Submission - Warragamba Dam Raising Project - SSI-8441

Thank you for the opportunity to submit on the Preferred Infrastructure Report (PIR) for the Warragamba Dam Raising Project (the "Project").

Figure 13-1. Summary of the proposed approach to implementing the Warragamba Offset Program

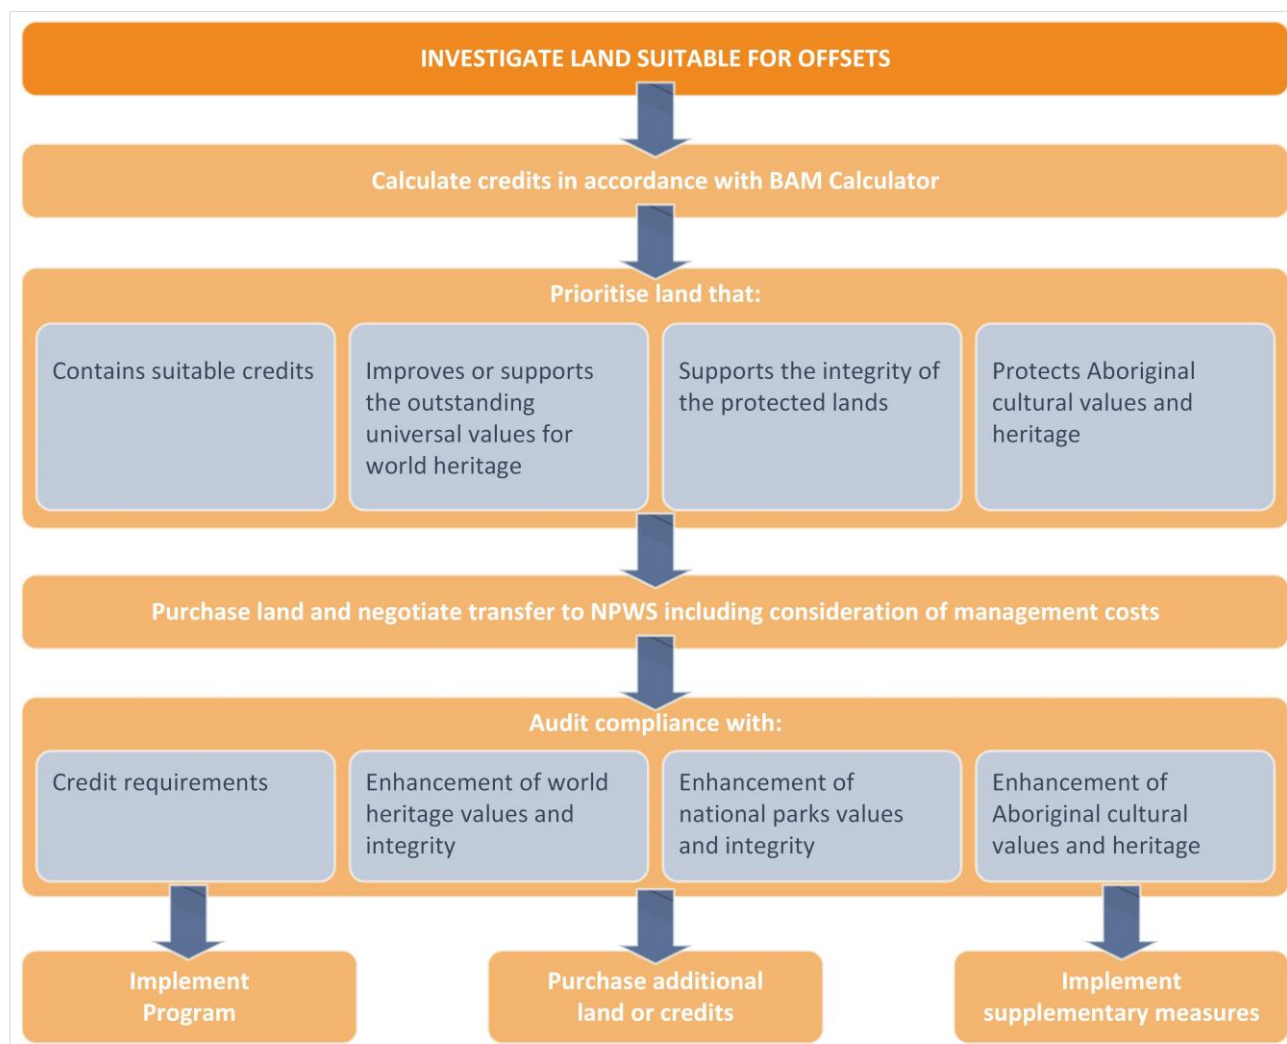
The EIS acknowledges that the Project will result in significant environmental/ecological damage to the Greater Blue Mountains World Heritage Area ("GBMWH") and adjoining national park (together, the "Blue Mountains" or "BM") but proposes the Warragamba Offset Strategy to deliver "environmental offset credits" such that it concludes that there will be an overall conservation gain from the Project. In my view this approach and conclusion is deeply flawed and quite frankly, absurd.

You simply cannot destroy part of the BM and argue that this can be compensated for by acquiring an equivalent amount of land as a national park elsewhere in the state or by making monetary contributions to a biodiversity fund. This is analogous to saying "its okay to destroy one of the sails on the Sydney Opera House (and leave it in a state of disrepair) because we're going to build a new cultural centre in Broken Hill which will result in a net cultural benefit for the state".

The PIR adopts a “revised offset strategy” to prioritise identification and costing of a series of “on park management actions” which will go beyond “business as usual”. Otherwise the offset strategy is in substance the same as in the EIS and continues to be flawed for the reasons stated above. The PIR states that biodiversity offsets are an accepted and adopted method of compensating for the impacts of a development. However in my view they are completely inappropriate in relation to an iconic natural asset like the Blue Mountains.

Figure 25-11. Viewpoint 1-1: Echo Point Lookout showing Project upstream impact area

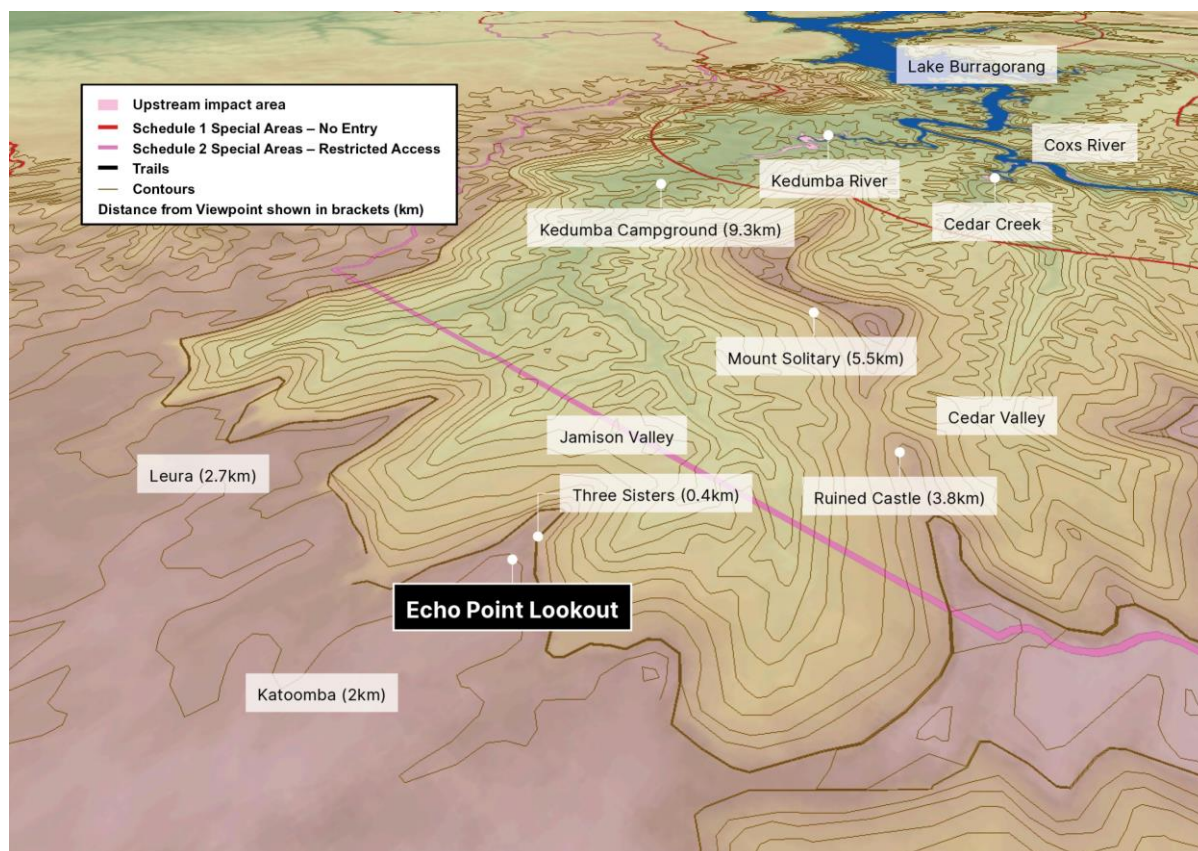
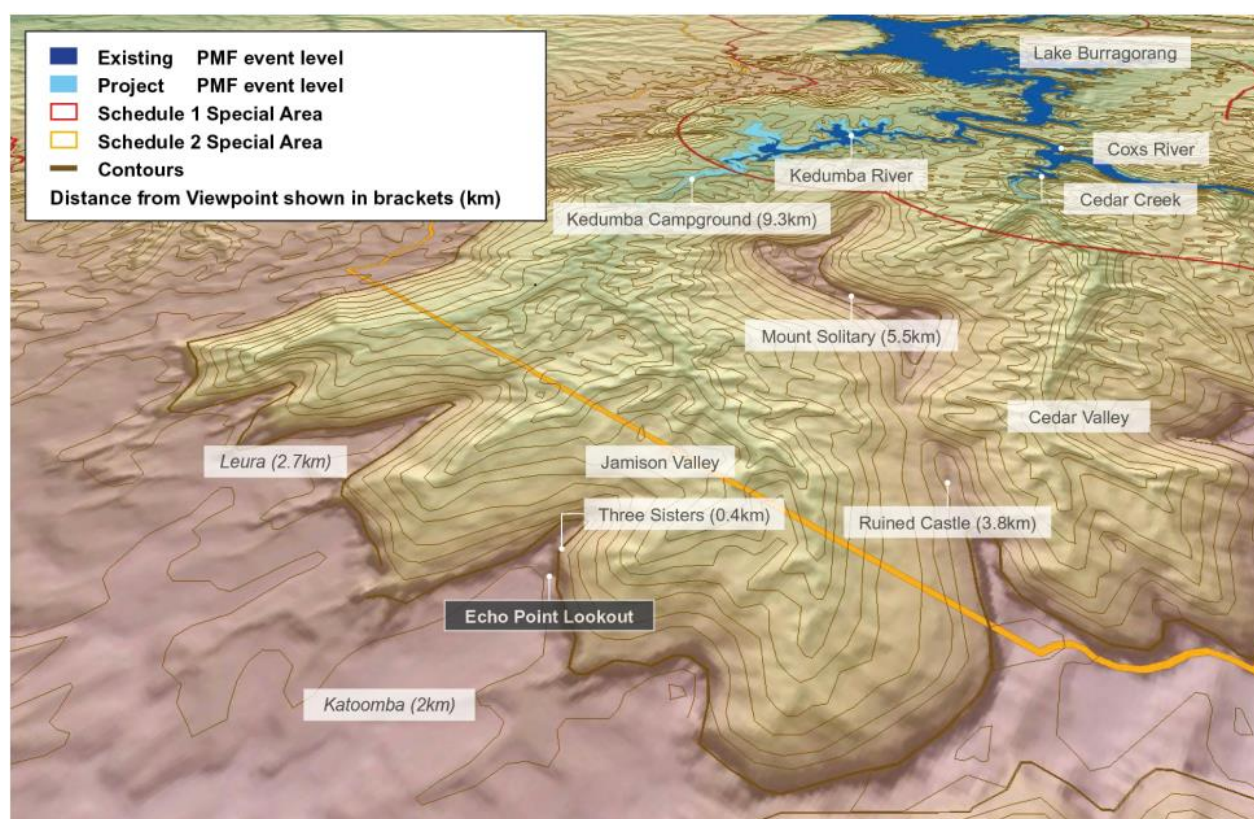
In Chapter 25, and in the Executive Summary, the EIS concludes that the visual impact of the Project when considered from various viewpoints in the Blue Mountains such as Echo Point lookout will be negligible. This conclusion is repeated without analysis in other parts of the EIS, for example in the Biodiversity Assessment Report in Appendix F1. This conclusion is plainly wrong, and is inconsistent with the report “Landscape Character and Visual Impact Assessment” in Appendix P prepared by external consultants SCAPE Design.

In concluding that the impact on visual amenity will be “Negligible” in Chapter 25 and in the Executive Summary, the principal authors of the EIS seem to have simply applied an equation:

“High” minus “High” equals “Negligible”

With due respect, this approach is either extremely sloppy or disingenuous, and raises questions for me as to what other conclusions in the report are based on such superficial reasoning and methodology.

It is particularly worth noting that the scarring will become increasingly evident from lookouts to the east of Echo Point where the viewshed is not obscured by Mt Solitary as is the case with Echo Point. I appreciate the reasons why Echo Point was chosen as a viewpoint, but had the EIS also included another more easterly lookout like the popular Sublime Point in Leura it would have given a much more balanced perspective on the loss of visual amenity from the Project.
